Re: ABP case reference : 324258

Applicant : Constant Energy Limited_Tirawley wind farm

In ABP case reference **324258** to which this observation refers, the applicant has, as one can see in Map 1, next page, ignored the turbine separation distances from adjacent turbines, that are recommended in the WEDG2006 guidelines.

- NOTES
1. FIGURED DIMENSIONS ONLY TO BE TAKEN FROM THIS DRAWING.
  2. DRAWING TO BE USED FOR PLANNING PURPOSES ONLY.
  3. ALL LEVELS REFER TO ORDNANCE DATUM (MALIN HEAD).
  4. ENGINEER TO BE INFORMED OF ANY DISCREPANCIES BEFORE ANY WORK COMMENCES.

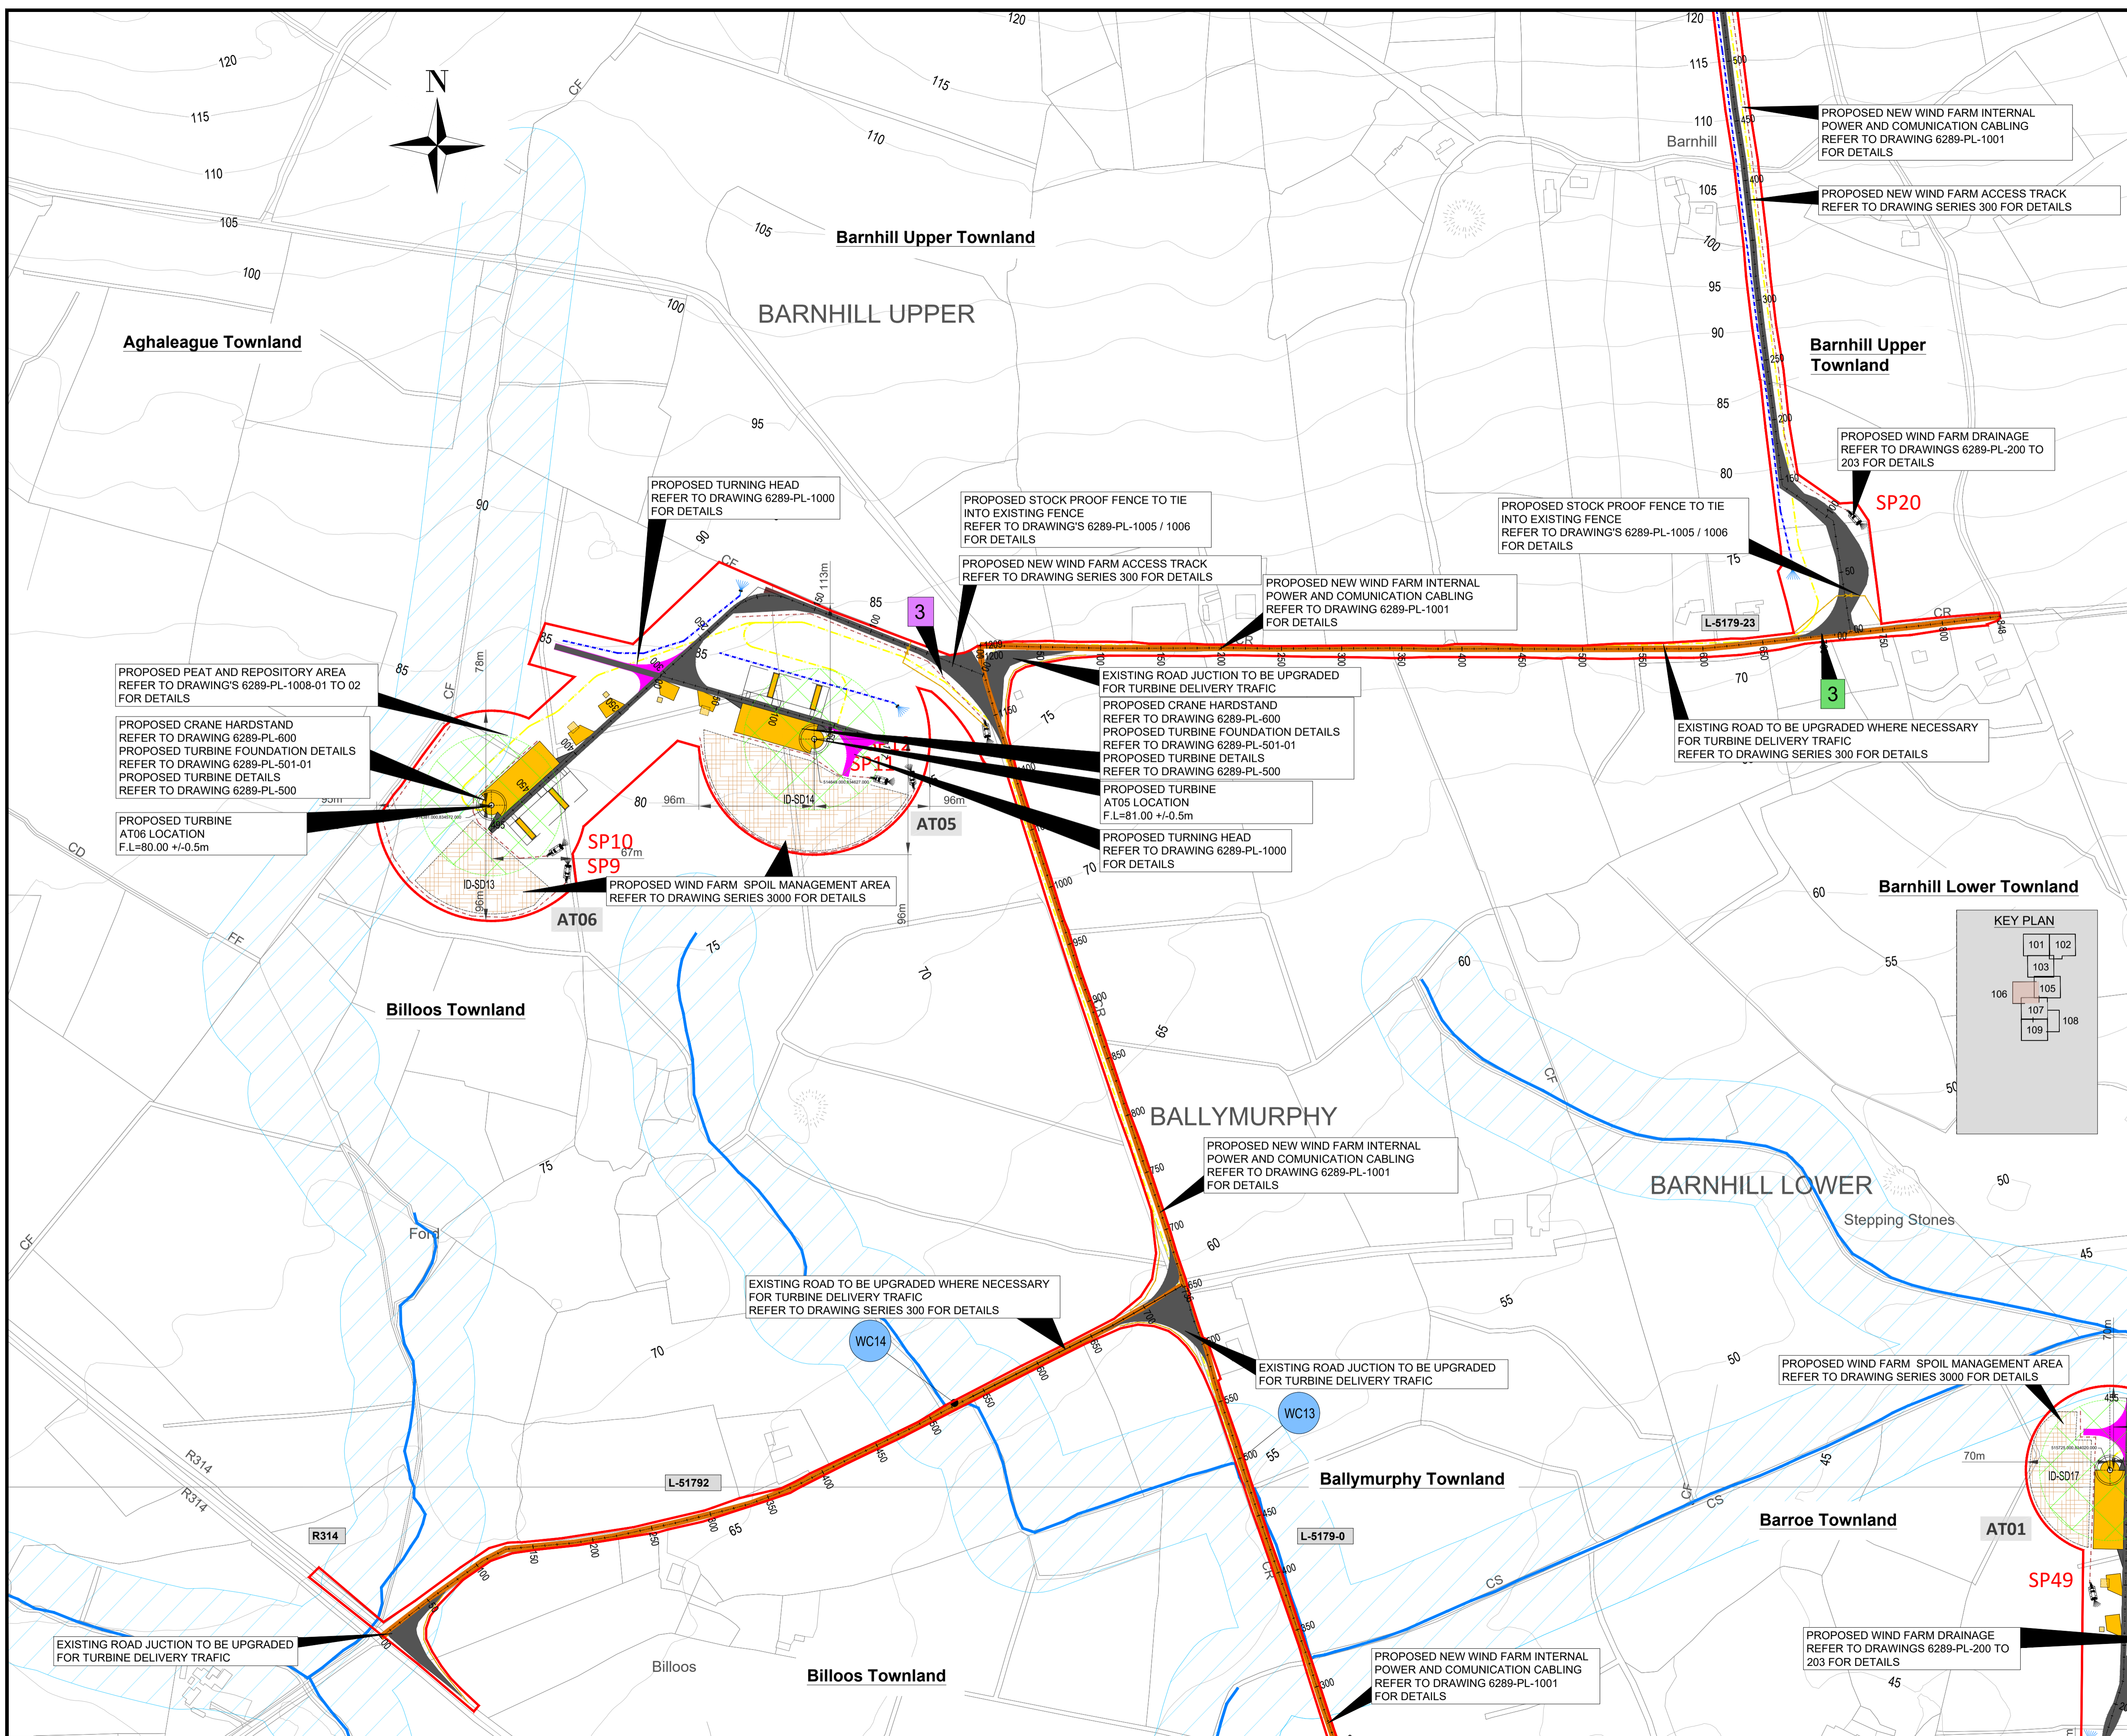
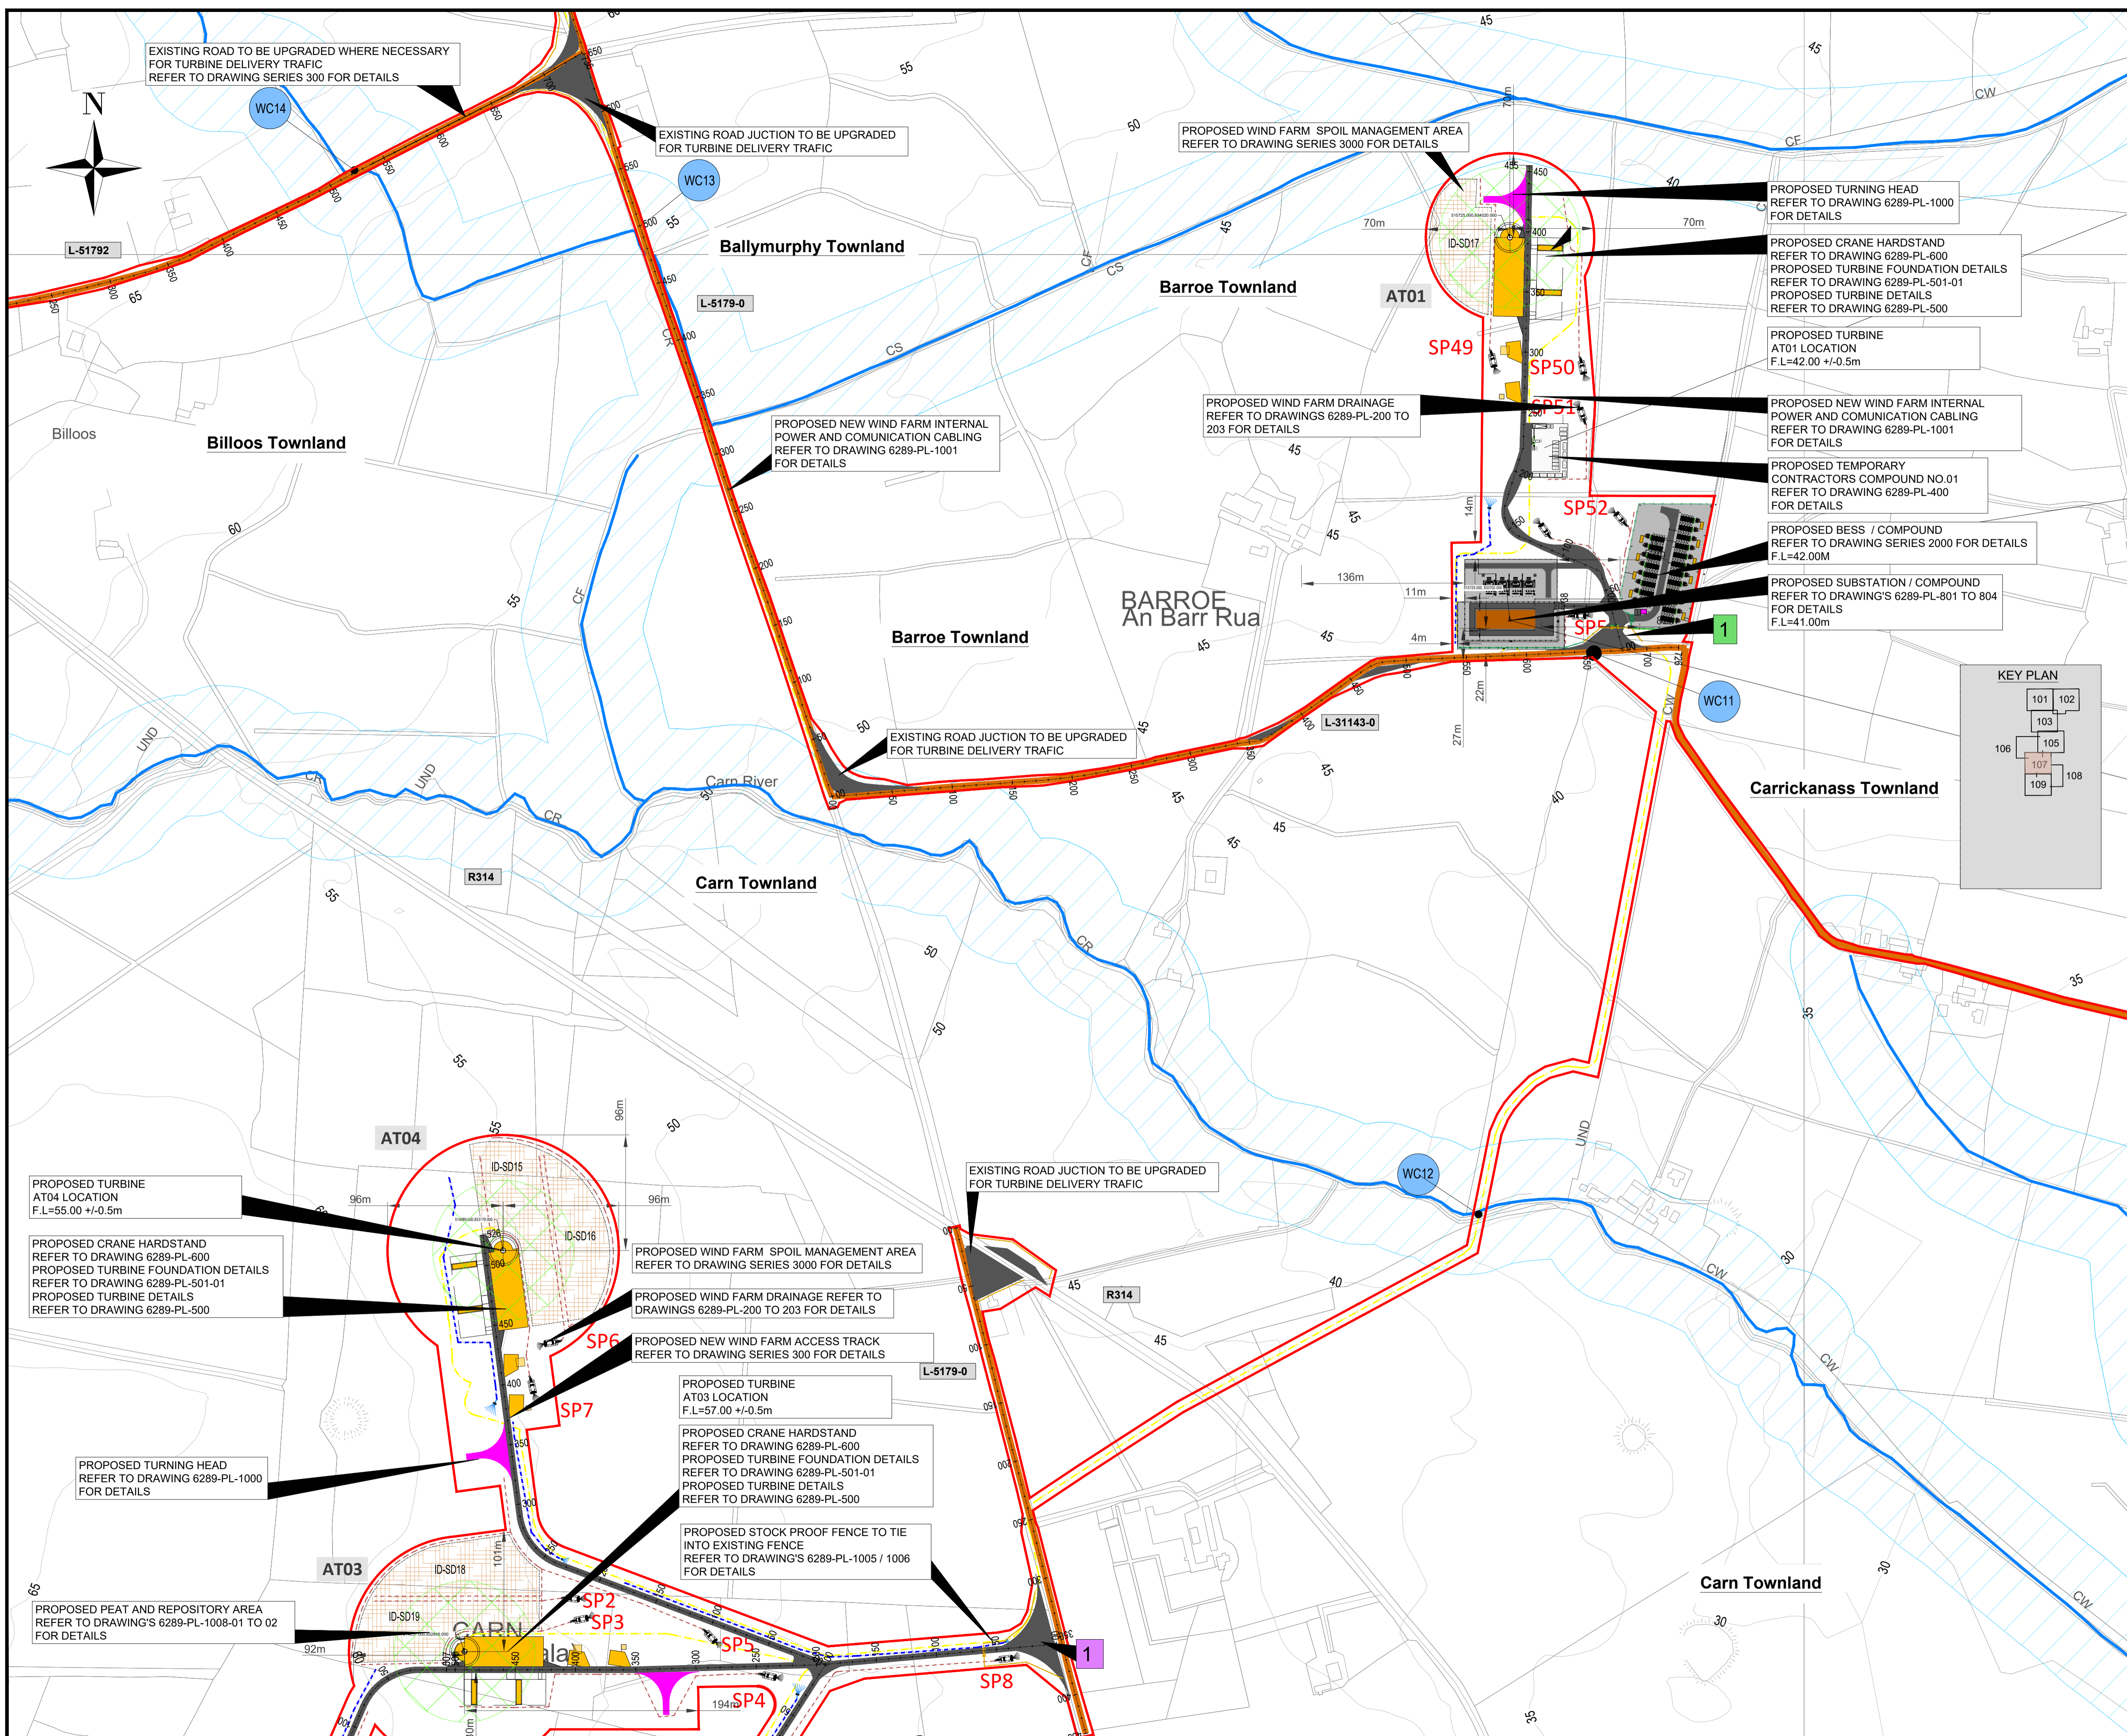
AT3 to AT4 has only 2.86 rotor diameters instead of 7 rotor diameters. 41% of required separation
AT6 to AT5 has only 2.34 rotor diameters instead of 7 rotor diameters. 33% of required separation
AT7 to AT8 has only 2.43 rotor diameters instead of 7 rotor diameters. 35% of required separation
AT9 to AT10 has only 2.38 rotor diameters instead of 7 rotor diameters. 34% of required separation
AT11 to AT13 has only 2.87 rotor diameters instead of 7 rotor diameters. 41% of required separation
AT13 to AT14 has only 3.13 rotor diameters instead of 7 rotor diameters. 45% of required separation
AT11 to AT14 has only 4.30 rotor diameters instead of 7 rotor diameters. 61 % of required separation

I would also include AT2 to AT3, AT10 to AT11, AT15 to AT16 & AT12 to AT13 in those 7 rotor diameter separation requirement as they have not a much lesser prevailing winds from the South Southeast and the West northwest directions.

On the basis of what I have outlined and experienced, I highly recommend the aforementioned issues be carefully considered, and the design be altered significantly.
